re: Geotechnical Recommendations - Grading Plan Review and Frost Protection
Proposed Warehouse Buildings
Campeau Drive at Huntmar Road
Ottawa, Ontario

date: May 30, 2023

file: PG6394-MEMO.02

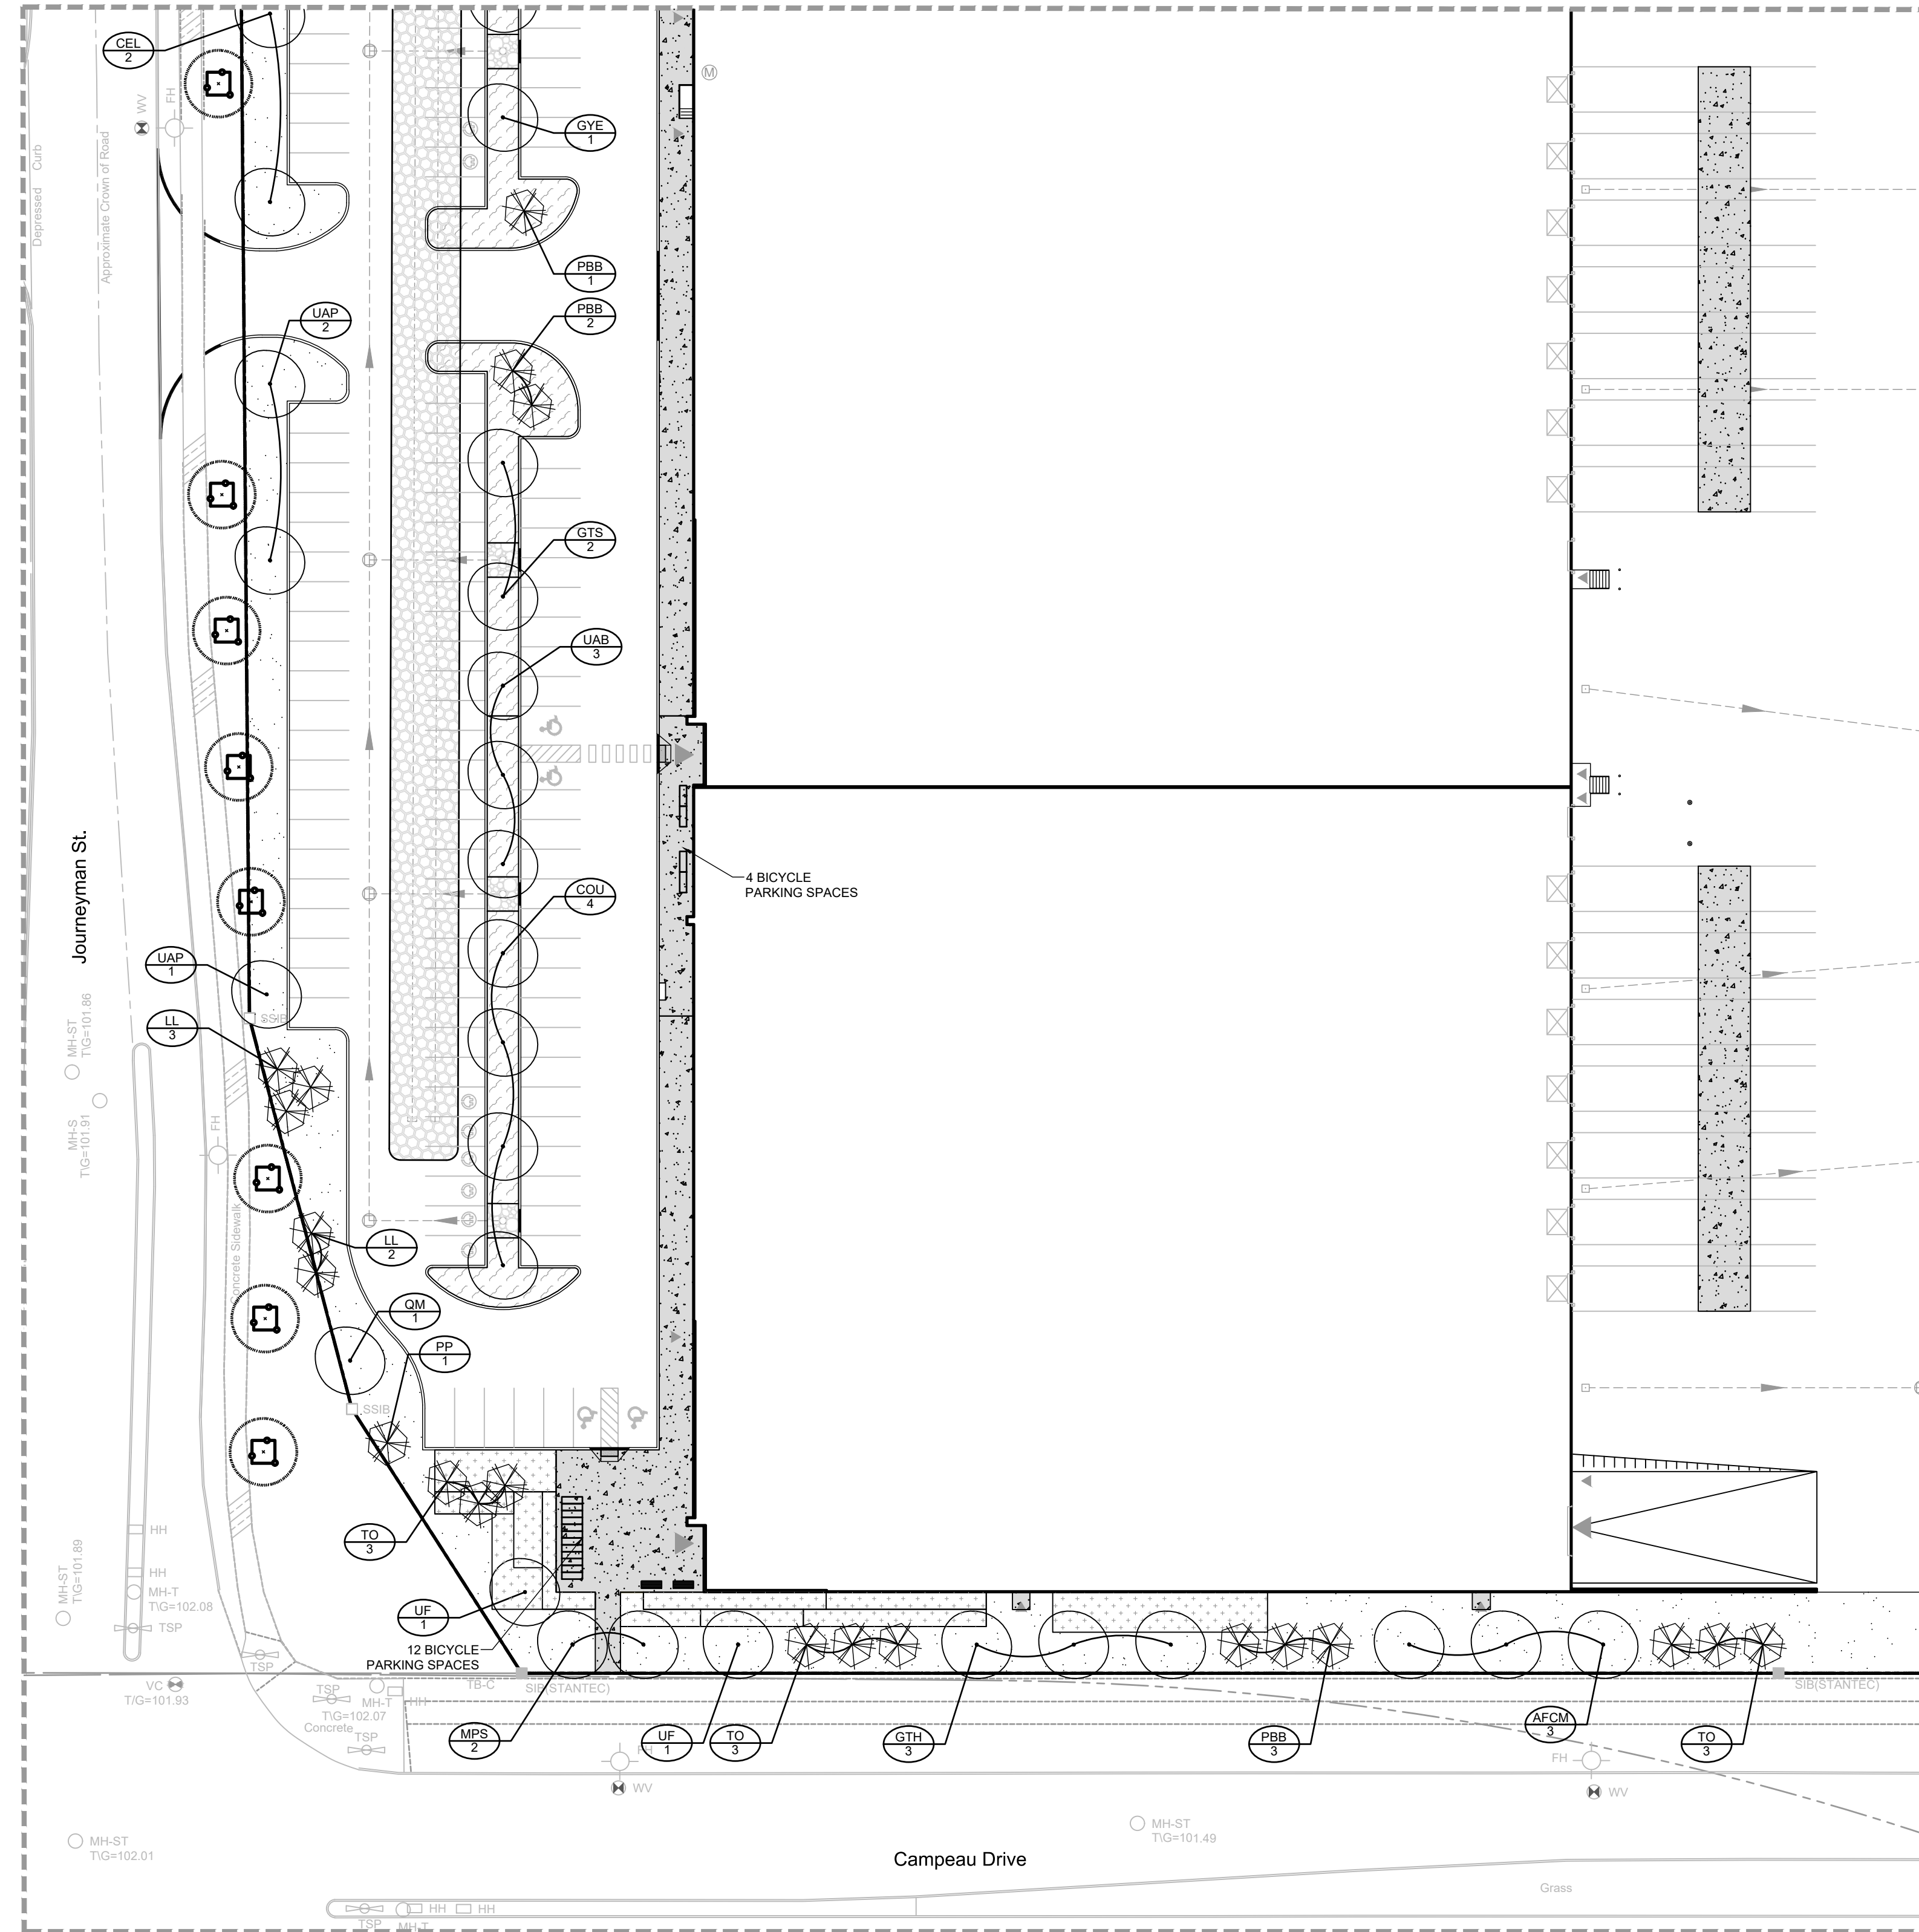
Based on our review of the above noted drawings, all footings were observed to have sufficient horizontal setback from proposed trees with the exception of some LL, UAP, and QM trees within buildings B1, B3, and B4, noted in the above table. These trees should either be sufficiently spaced from the building footprint at a minimum distance equal to the mature tree heights (20 to 30m) or should be replaced with small to medium trees with a maximum mature height of 14m.

Based on our review, it was further noted that the footings along the southern foundation wall of building B1 and the footings at the southeast corner of Building A1 will be located within 10m from the proposed trees, and therefore, will require to have a minimum embedment depth of 2.1m below finish floor elevation as per City guidelines for planting in sensitive marine clays. To compensate for the reduced foundation depth for the impacted footings, an engineered fill pad can be placed below the underside of footing to an elevation matching a depth of 2.1 m below proposed finished grade surrounding the buildings. The engineered fill pad will effectively increase the depth between the finished grade and the underlying silty clay deposit to the required 2.1 m which achieves the same goal as lowering the footing from a tree planting perspective. The granular pad should consist of OPSS Granular A or Granular B Type II placed in 300 mm loose lifts and compacted to 98% of the material's SPMDD. The granular pad should be extended horizontally a minimum of 150 mm beyond the footing edges in all directions and a minimum 1.5H:1V down and out from the footing face. Reference can be made to Figure 1 - Engineered Pad Below USF For Tree Planting Purposes attached for additional information.
